DRB Application No.: 07DRB-00601 (SBP)  
Project Name: TOWN OF ATRISCO GRANT UNIT 7  
Agent: Tierra West LLC

TO: Sheran Matson, DRB Chair  
FROM: Stephanie Shumsky, Planner  
SUBJECT: Project # 1005242

On December 21, 2006, the Environmental Planning Commission approved Project # 1005242/06EPC-01588, a request for a site development plan for building permit for all or a portion of Tract A-1-E, Unit 7, Town of Atrisco Grant, located on Sage Road SW between Snow Vista Blvd. SW and Reba Road SW, containing approximately 2-acres.

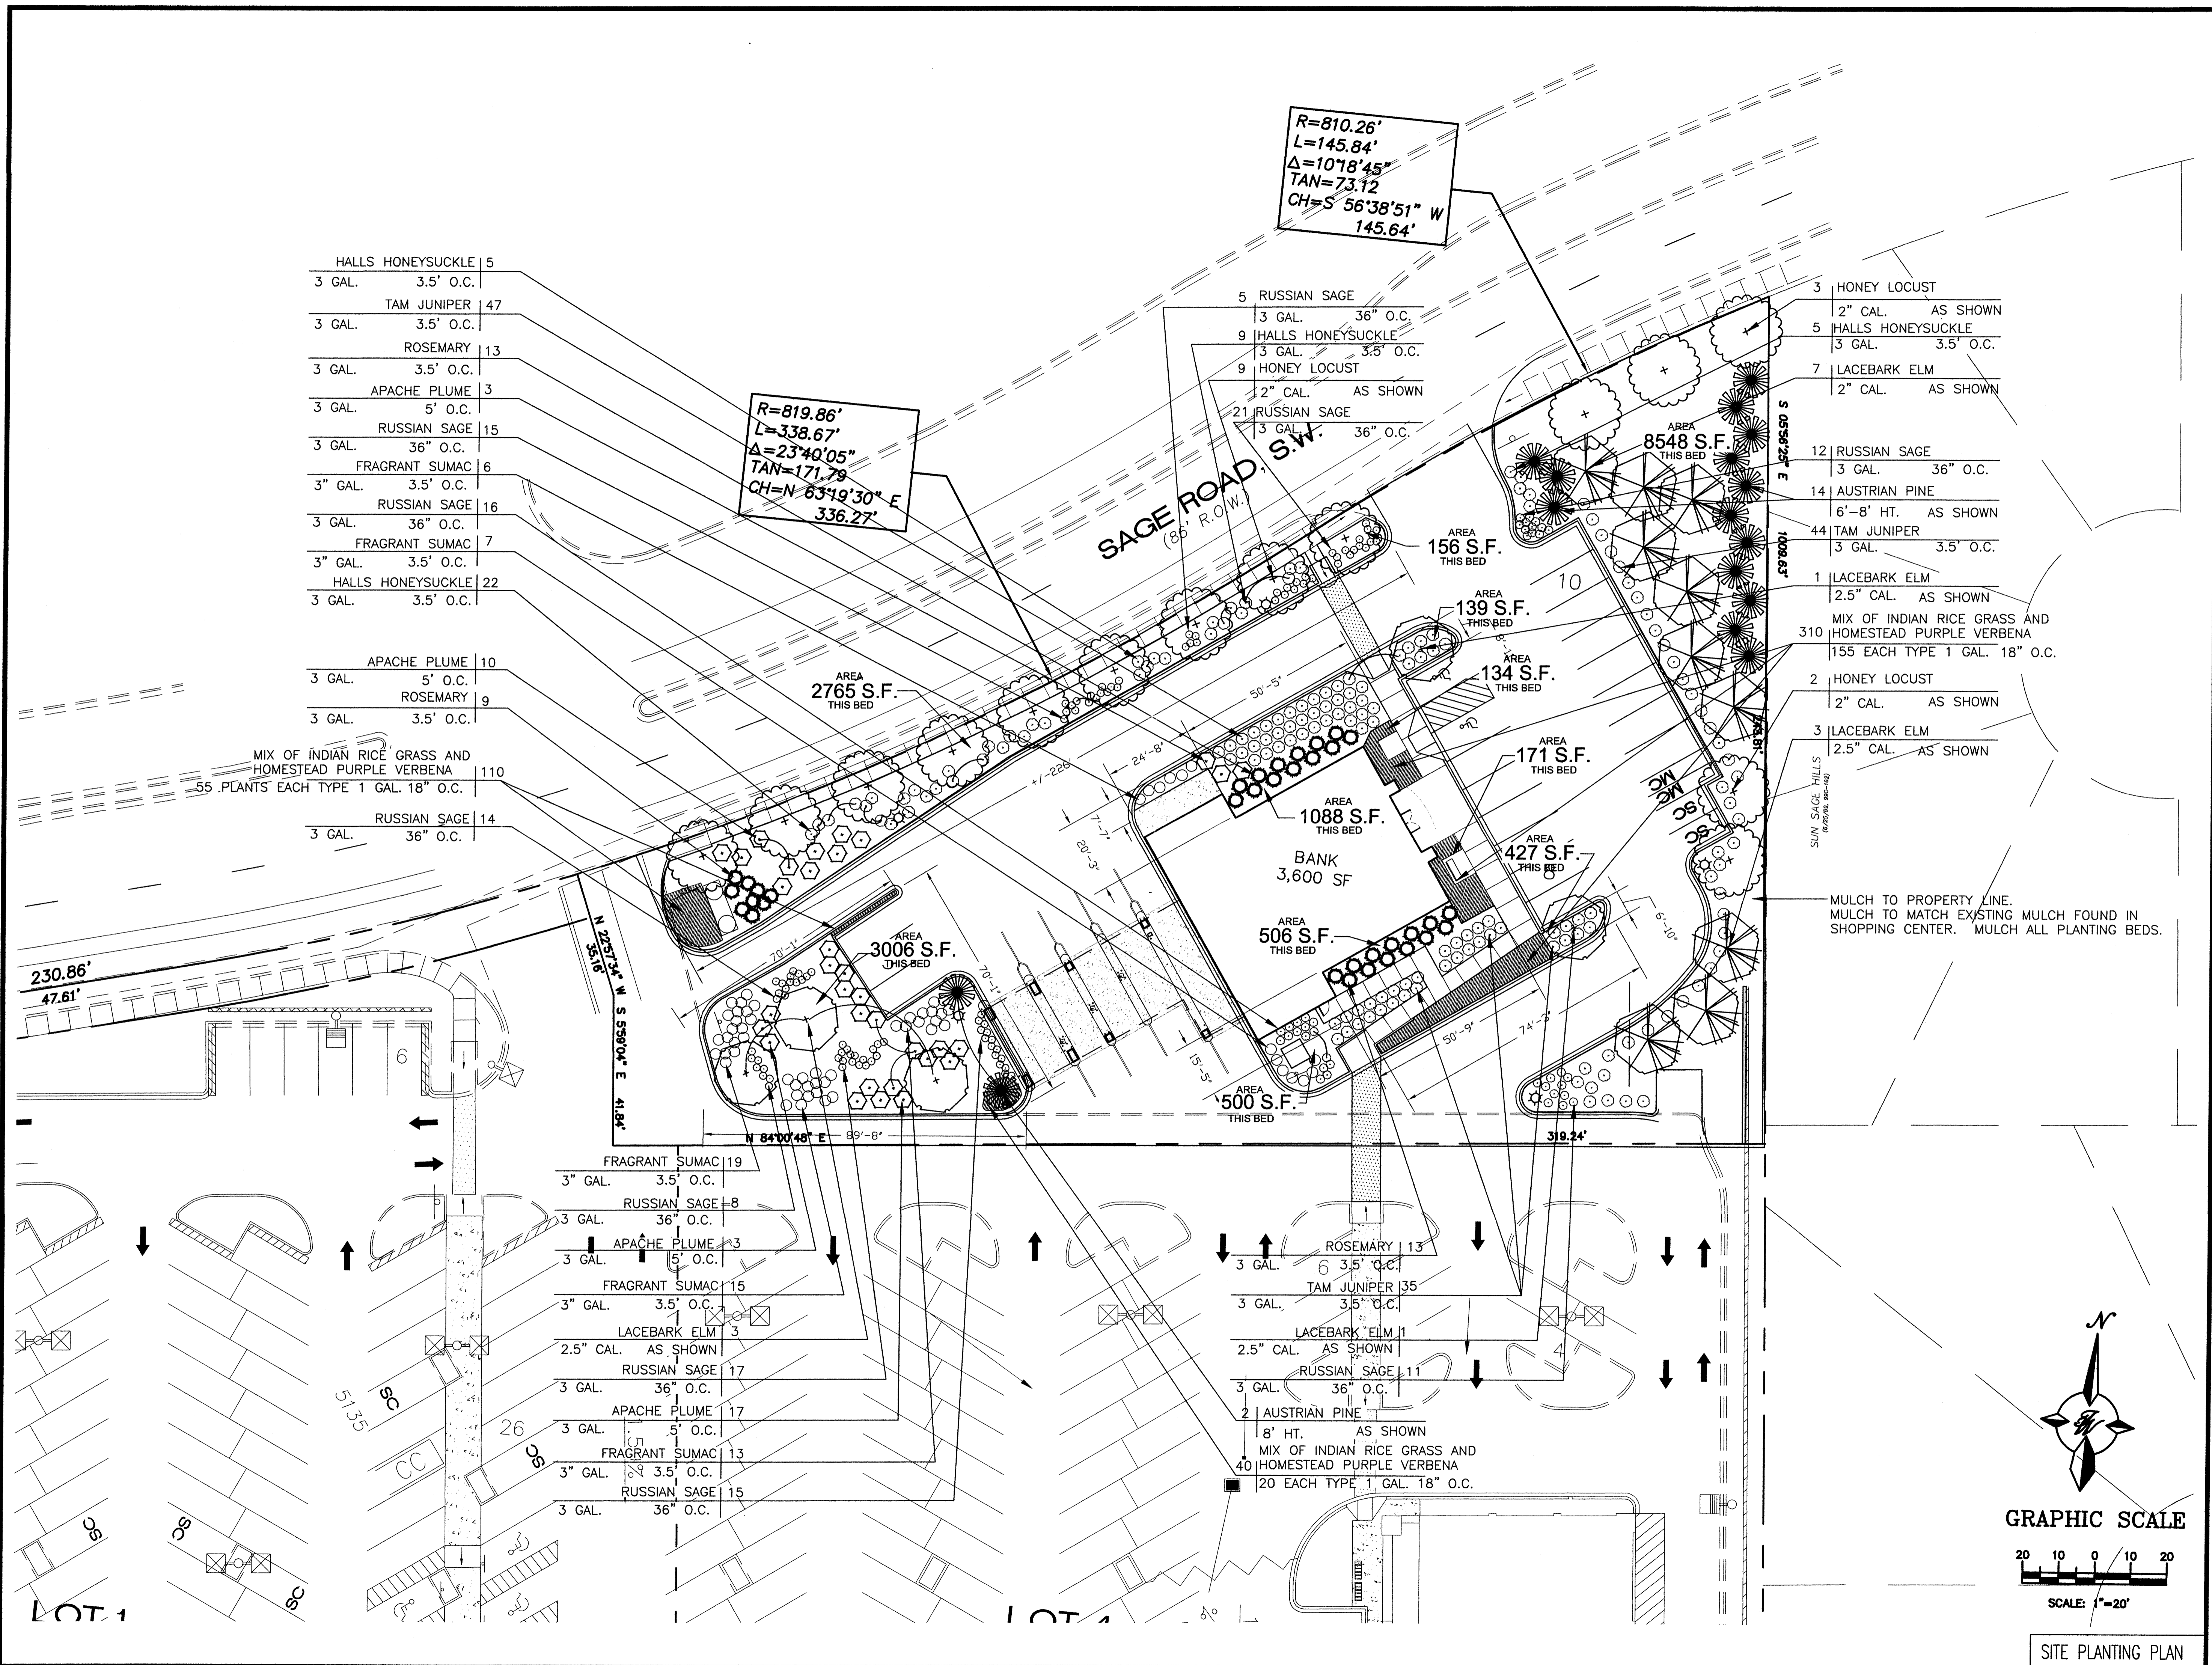
1. Condition #6. "The Landscape Plan shall specify water-harvesting methods utilized on the site."  
*Water harvesting methods are not specified on the Landscaping Plan.*
2. Condition #11. "The City Forester shall be contacted prior to DRB submittal to ensure that all of his concerns and comments are addressed adequately."  
*The DRB application letter submitted by the applicant states that this condition was met, however the letter referred to, which documents the meeting with the City Forester, is not included in the DRB submittal. This letter must be included in the submittal.*
